Lawful Development Certificate for a Proposed Use or Development

Development: Lawful development certificate for a single storey rear extension.
Location: 14 Downview Avenue Ferring BN12 6QN

Site / Block / Roof Plan as Proposed

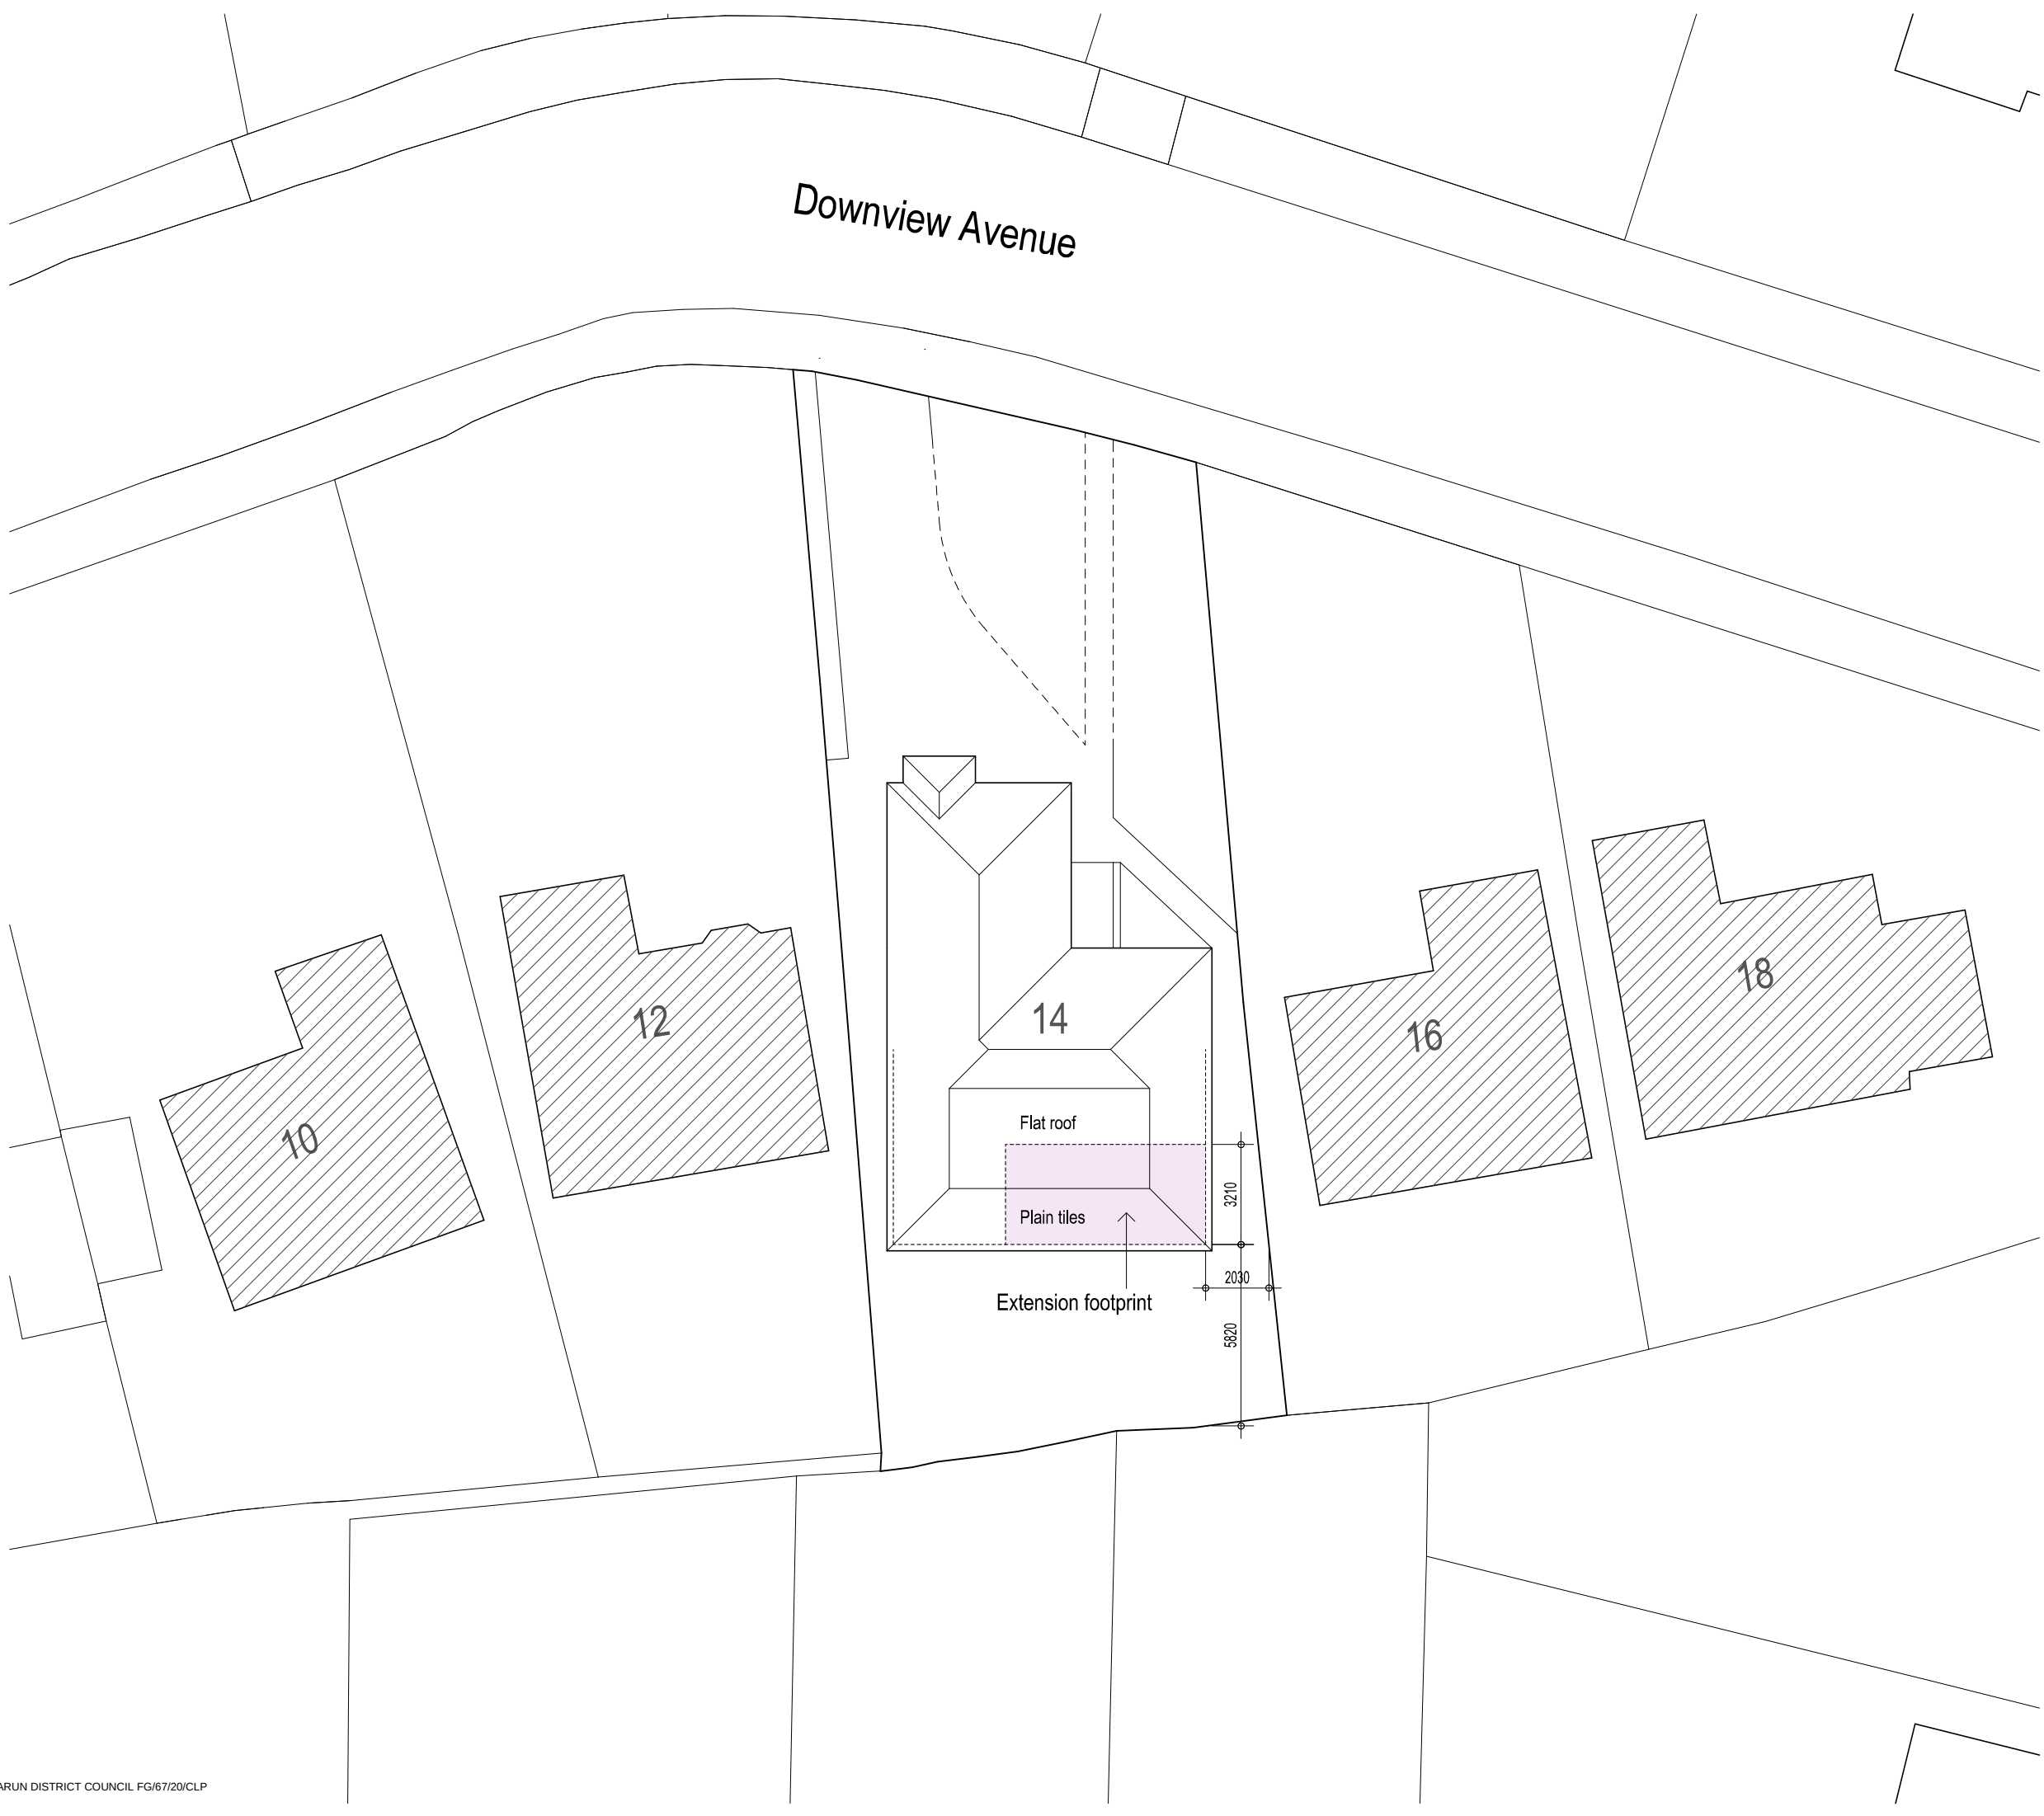
Block Plan

Please amend the Block Plan to include measurements to boundaries and re submit.
